MDT-SKP22005-R1-TIS-redlines.pdf Markup Summary

Please add PCD File No. SKP225

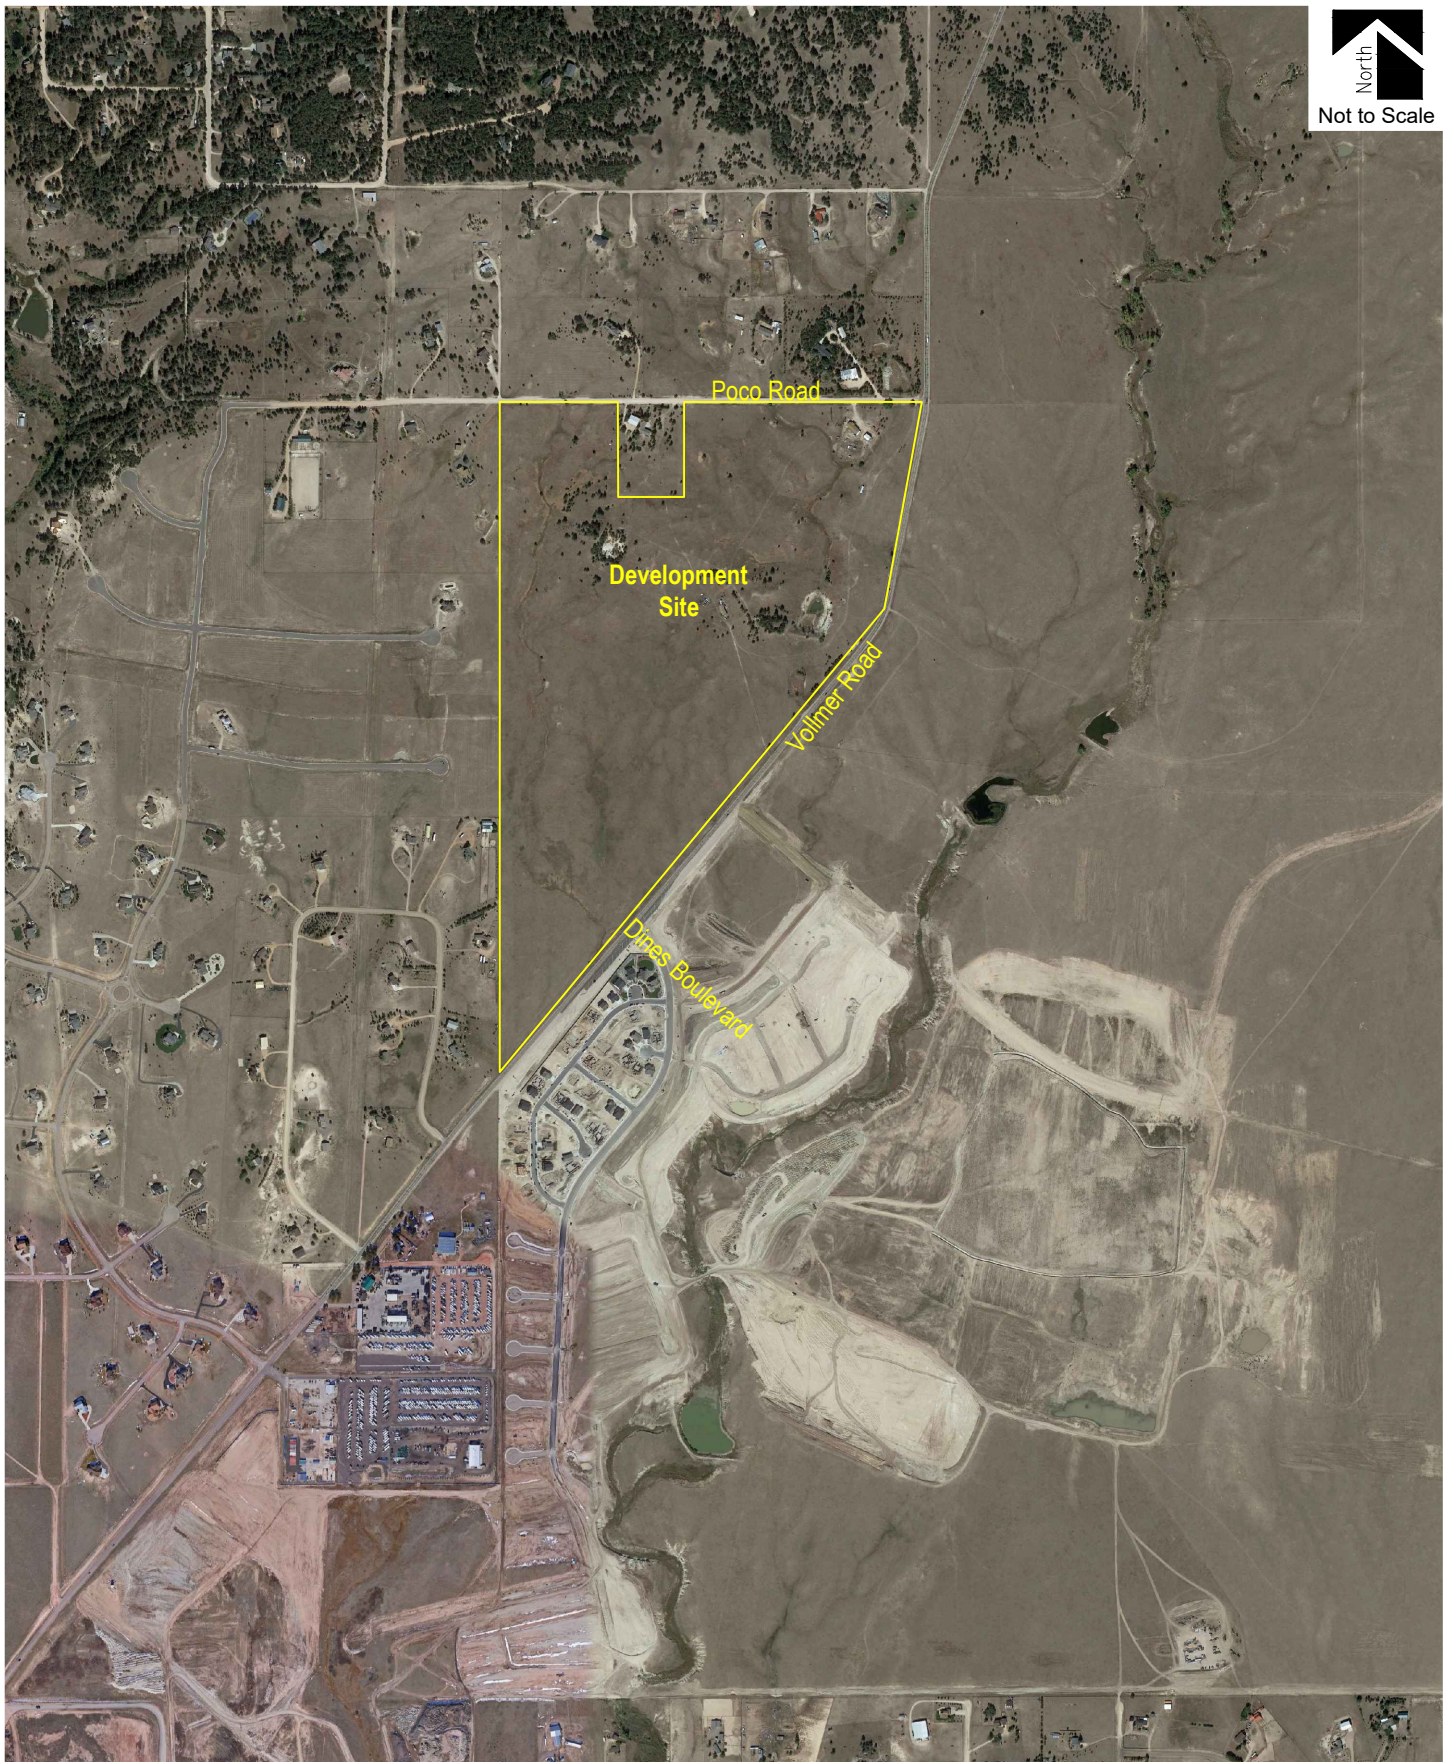
update this sketch plan drawing to match the current submitted plan.

Figure 6-A
SITE DEVELOPMENT SHORT-TERM DISTRIBUTION
(%) : Overall
SITE-GENERATED
AM / PM Peak Hour

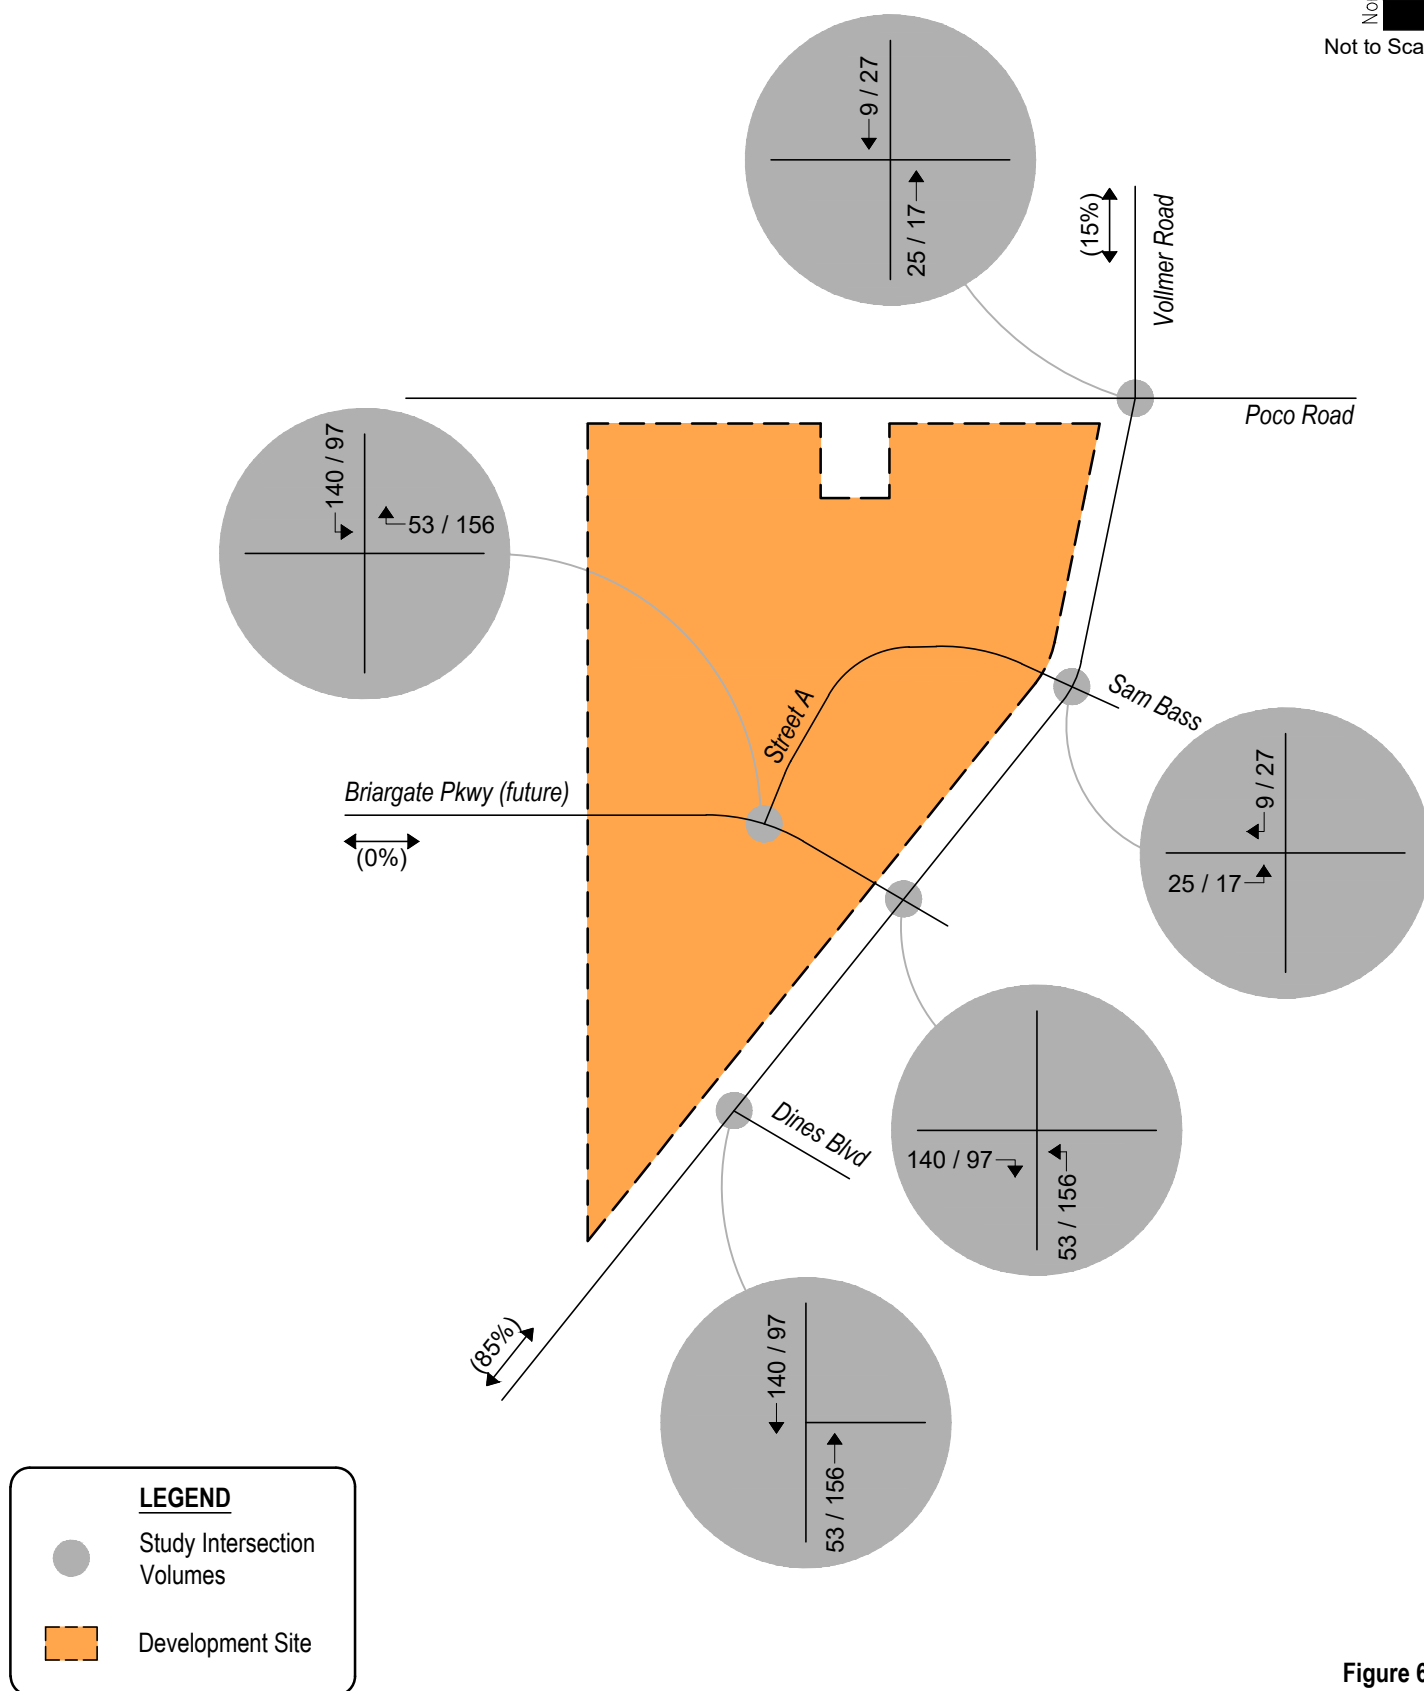
Please also provide an analysis for only one intersection at Briargate Pkwy.

The current briargate-stapleton corridor access control plan (see link below) only indicates one allowed intersection along this section of Briargate.

Figure 6-B
SITE DEVELOPMENT LONG-TERM DISTRIBUTION
(%) : Overall
SITE-GENERATED
AM / PM Peak Hour

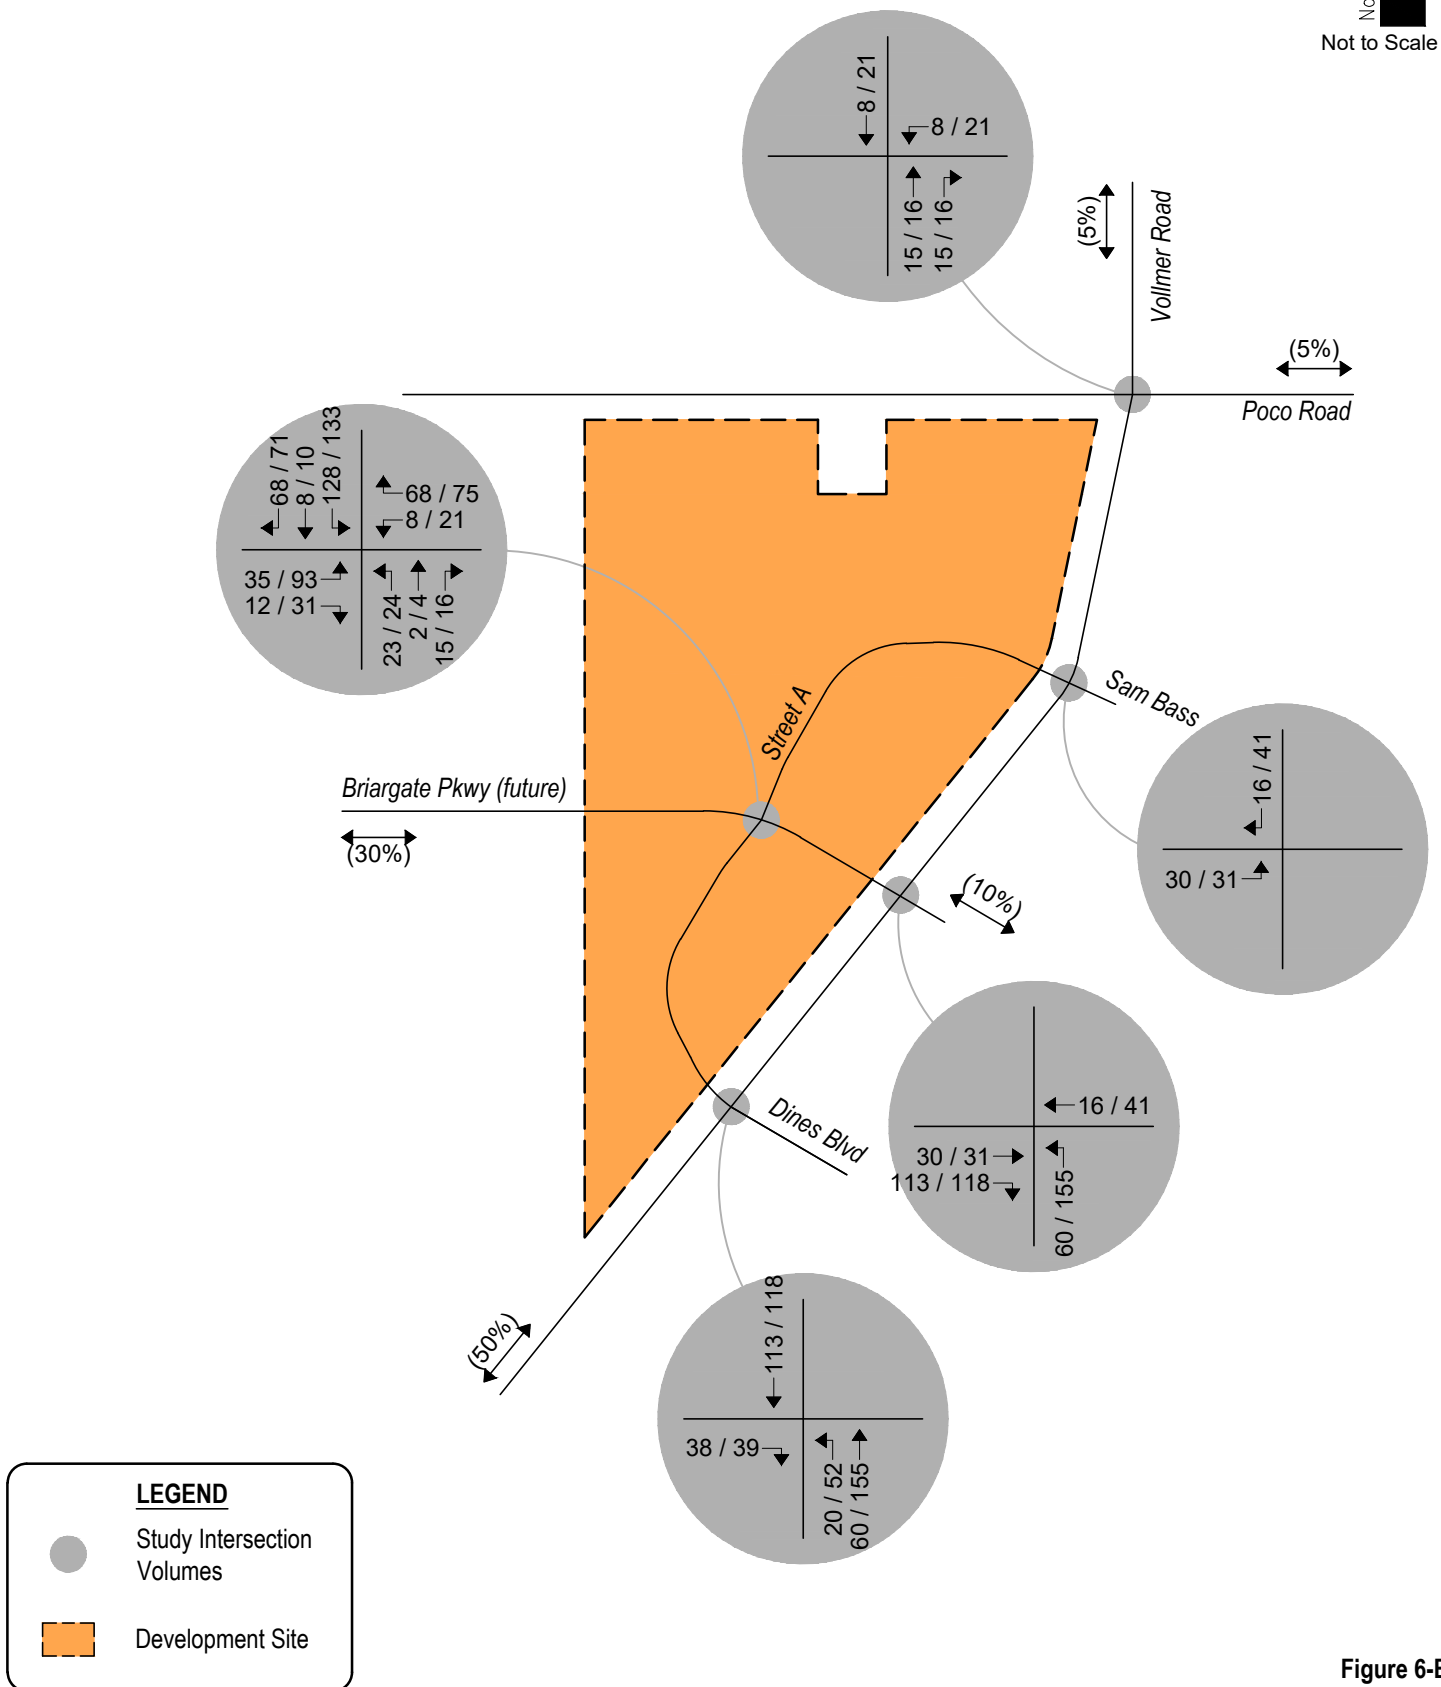
With the development of the commercial site, it is anticipated that the commercial site would generate traffic from retreat at timber ridge via Poco Rd. Please provide your reasoning for not attributing any site generated traffic to Poco

Figure 7
TOTAL TRAFFIC - YEAR 2027
Volumes & Intersection Geometry
AM / PM Peak Hour
(ADT) : Average Daily Traffic

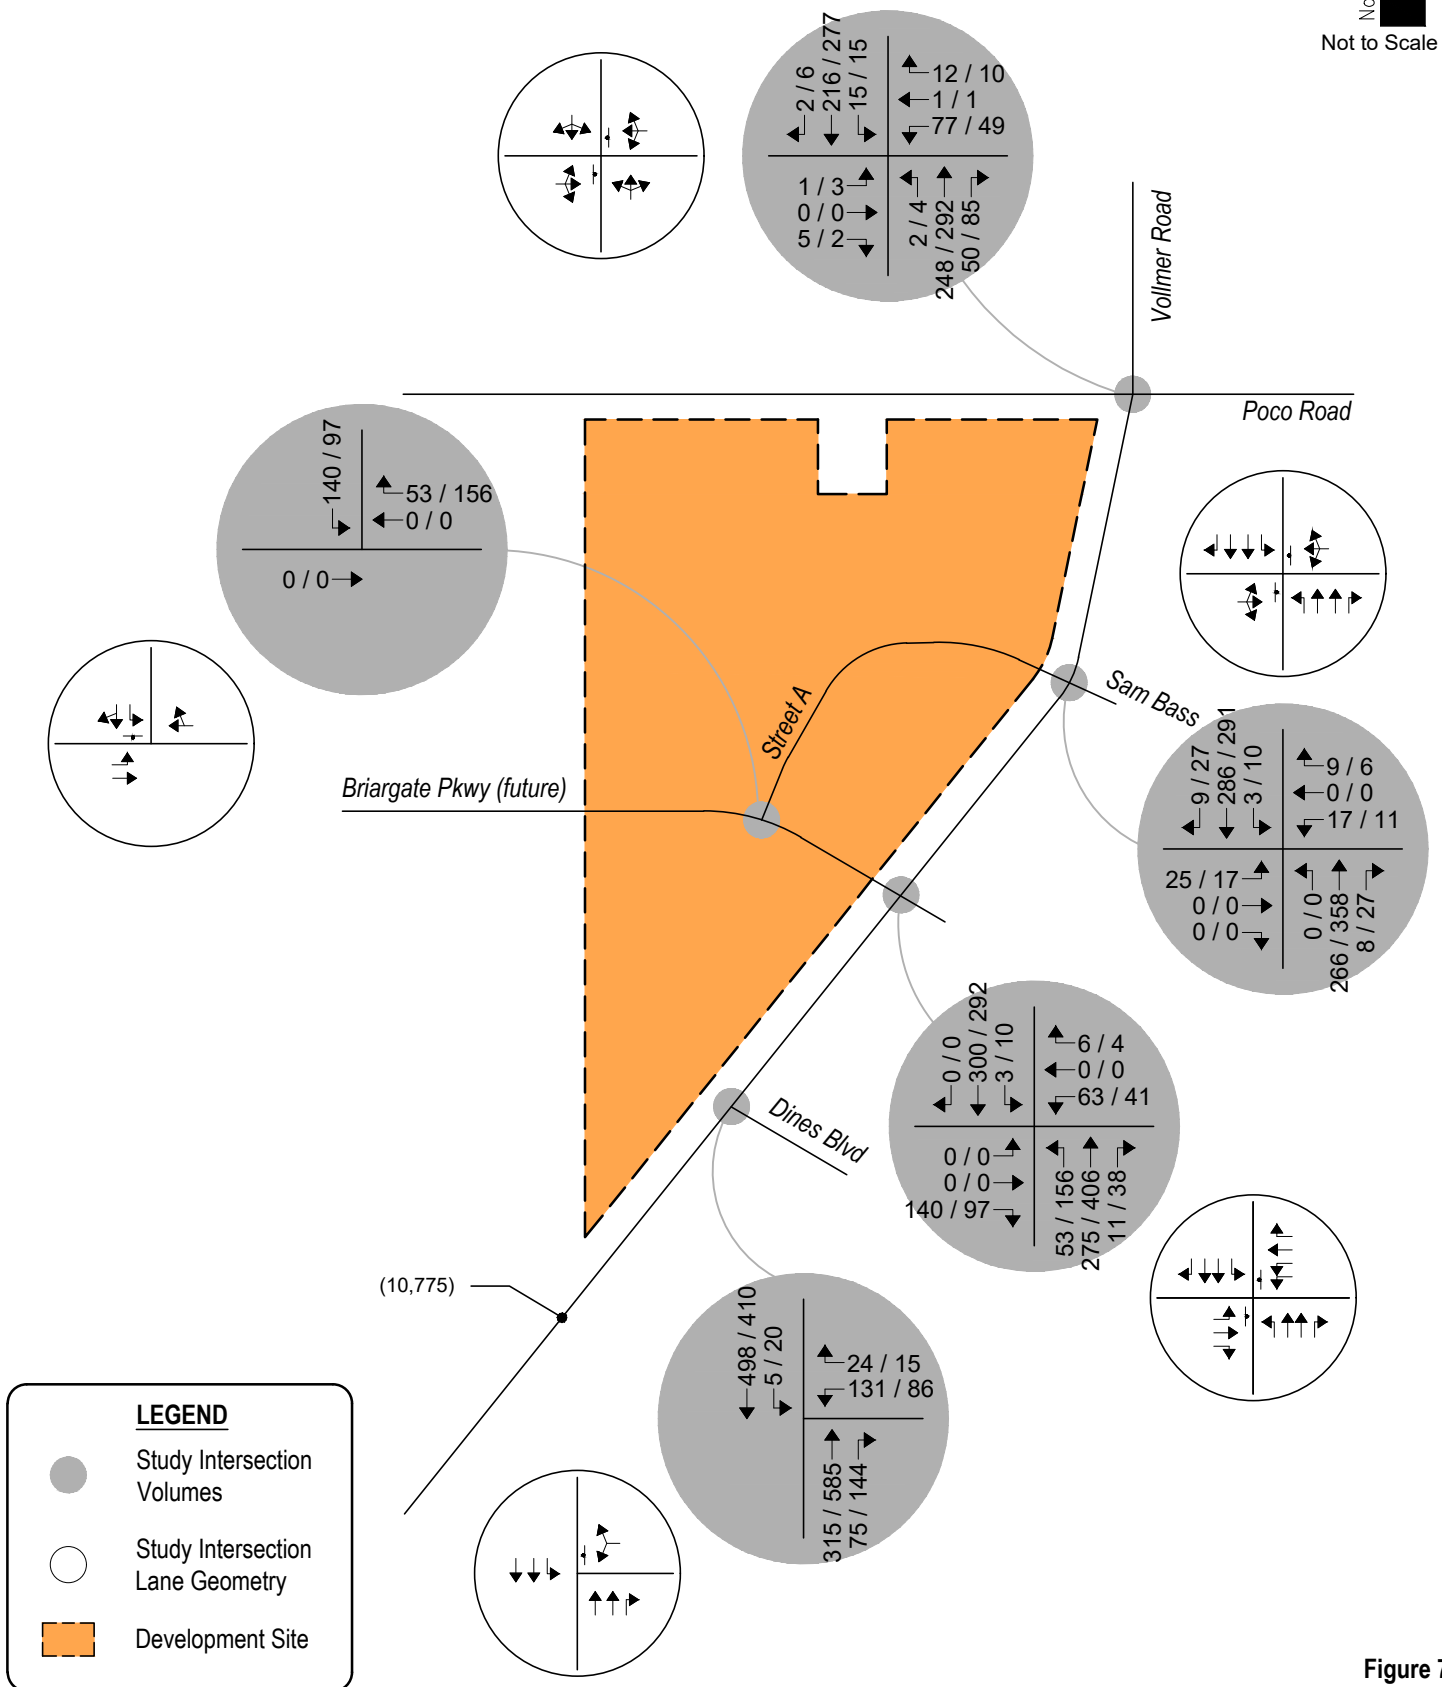
The submitted sketch plan identifies a proposed access from Briargate to the commercial site. Provide analysis at this access.
